Engineers Comments Regarding Surface Water Drainage

Subject: Planning Consultation on: BR/176/20/PL

Application No: BR/176/20/PL
Registered: 29th October 2020
Site Address: Ravenna Richmond Avenue West Bognor Regis PO21 2YG
Grid Reference: 492398 99034
Description of Works: Erection of a new building comprising of 3 No apartments (2 No 2 bed units & 1 No 1 bed unit) including alterations to the fenestration of the existing building. This site is in CIL Zone 4 (Zero Rated) as flats.

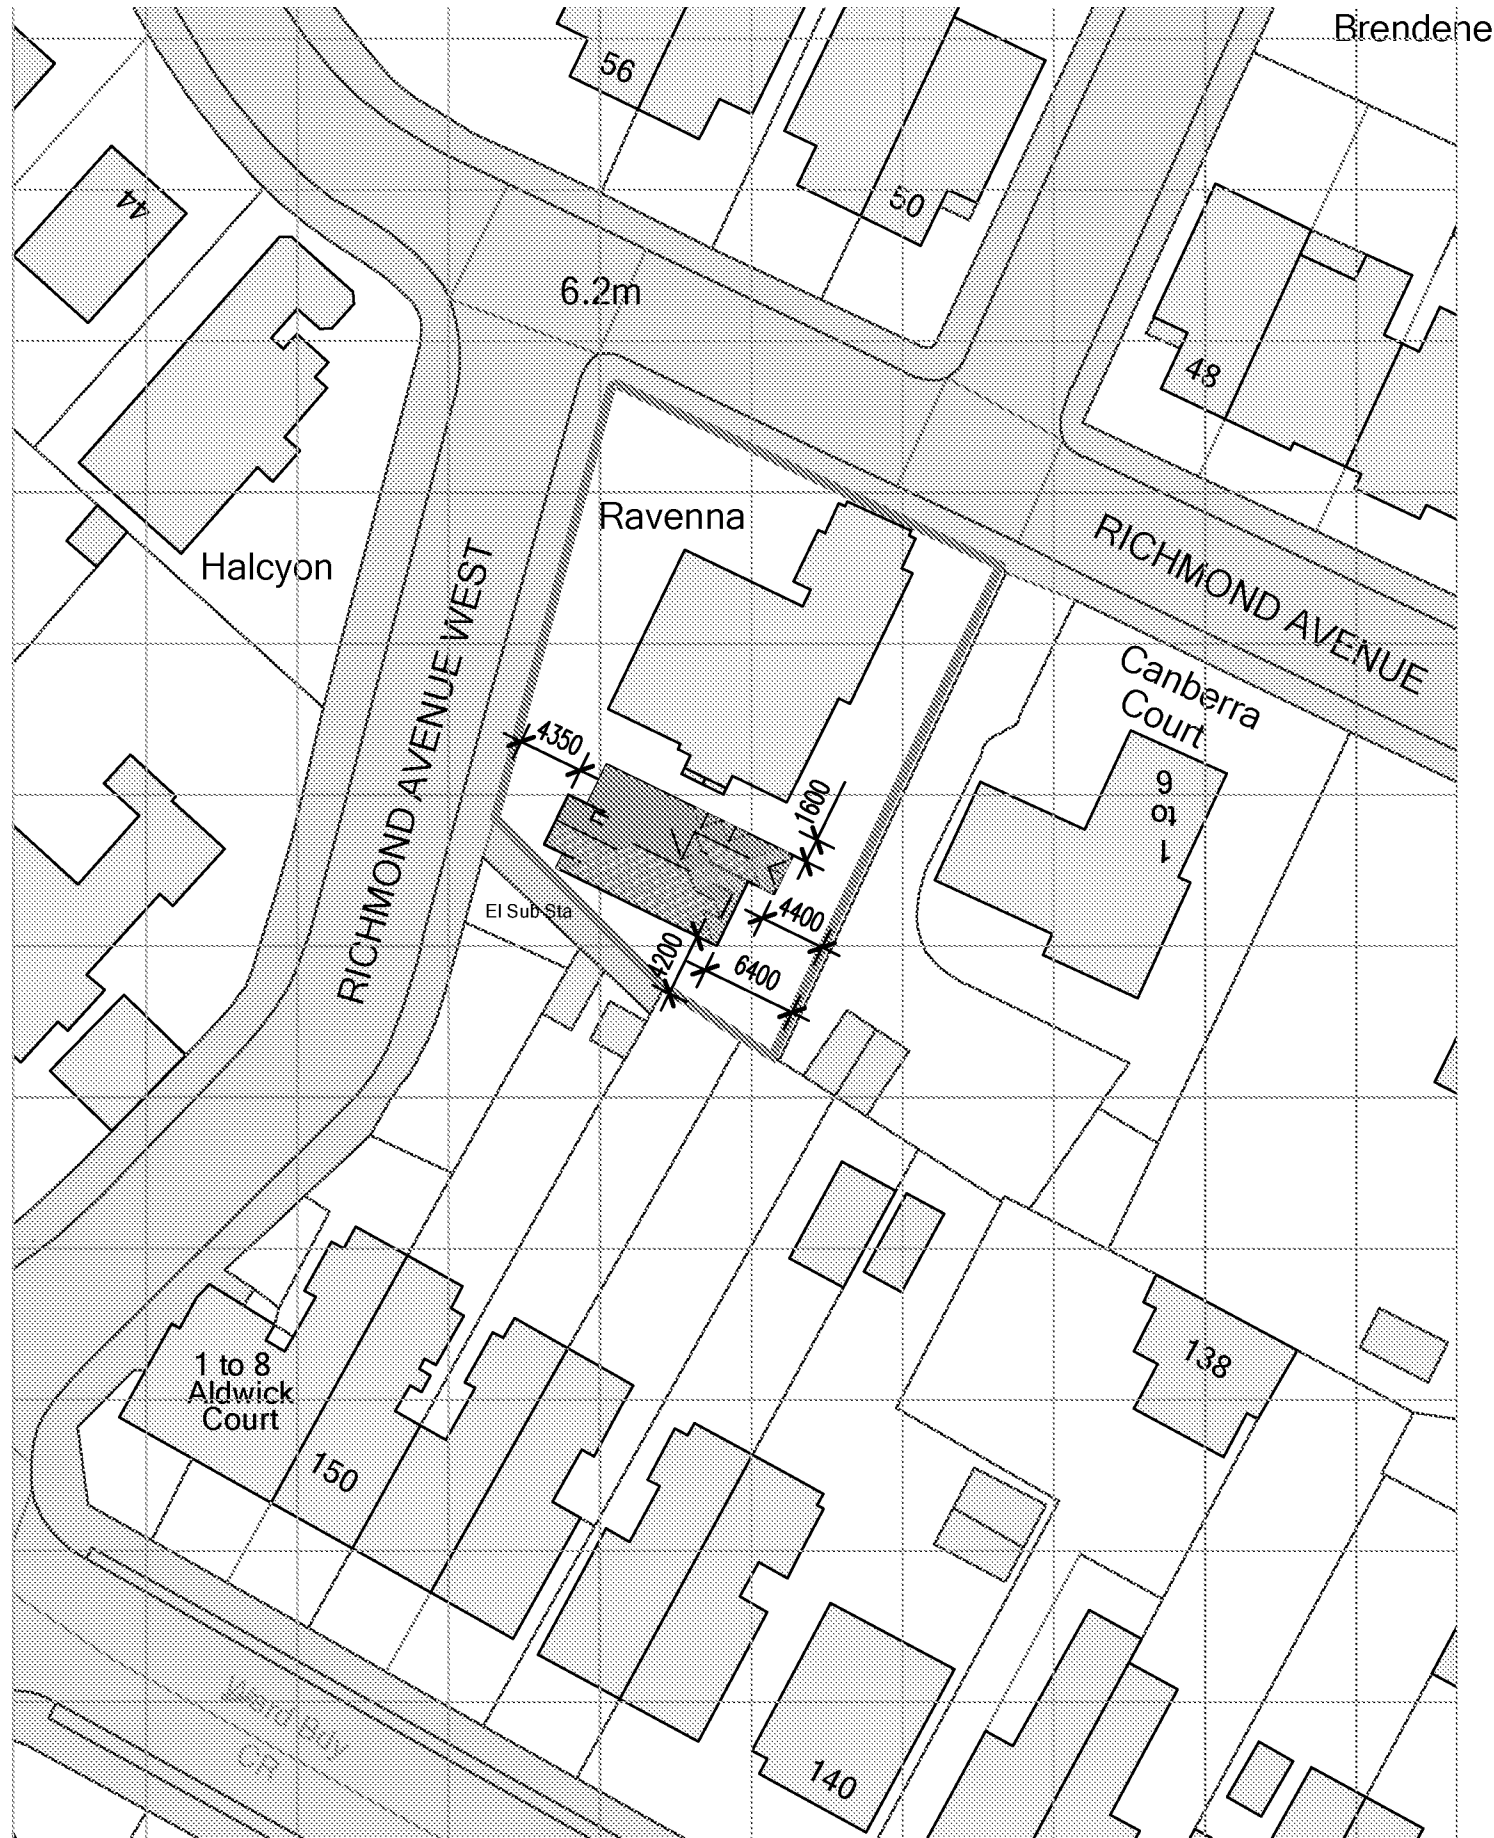
Surface water drainage must be considered at the earliest opportunity. Without winter groundwater monitoring and winter infiltration testing there is no way of determining the area take up required for an infiltrating surface water drainage solution and the hierarchy for sustainable drainage must be followed. If infiltration is viable on the site then lack of space is not an adequate excuse for not utilising soakaways/infiltration structures. Soakaways must be located a minimum of 5m from any buildings, and 2.5m from the site boundaries. Given these constraints, I do not see how surface water from the site can be sustainably drained within the remaining space on the site. There is also the risk that the proposed building may be located on the site of any drainage features for the existing building.

Therefore, I wish to lodge a holding objection to the application.

To overcome my objection the applicant should complete winter groundwater monitoring and winter infiltration testing and complete calculations to assess the size of structures required. A rough plan should be formed showing where these structures can be provided within the proposed layout. Detailed design of the system can be left until discharge of conditions where the applicant should provide the level of information stated within our checklist <https://www.arun.gov.uk/drainagechecklist>.

“Development shall not commence, other than works of site survey and investigation, until full details of the proposed surface water drainage scheme have been submitted to and approved in writing by the Local Planning Authority. The design should follow the hierarchy of preference for different types of surface water drainage disposal systems as set out in Approved Document H of the Building Regulations, and the recommendations of the SuDS Manual produced by CIRIA. Winter groundwater monitoring to establish highest annual ground water levels and winter Percolation testing to BRE 365, or similar approved, will be required to support the design of any Infiltration drainage. No building / No part of the extended building shall be occupied until the complete surface water drainage

"Infiltration rates for soakage structures are to be based on percolation tests undertaken in the winter period and at the location and depth of the proposed structures. The percolation tests must be carried out in accordance with BRE365, CIRIA R156 or a similar approved method and cater for the 1 in 10 year storm between the invert of the entry pipe to the soakaway, and the base of the structure. It must also have provision to ensure that there is capacity in the system to contain below ground level the 1 in 100 year event plus 40% on stored volumes, as an allowance for climate change. Adequate freeboard must be provided between the base of the soakaway structure and the highest recorded annual groundwater level identified in that location. Any SuDS or soakaway design must include adequate groundwater monitoring data to determine the highest winter groundwater table in support of the design. The applicant is advised to discuss the extent of groundwater monitoring with the Council's Engineers.
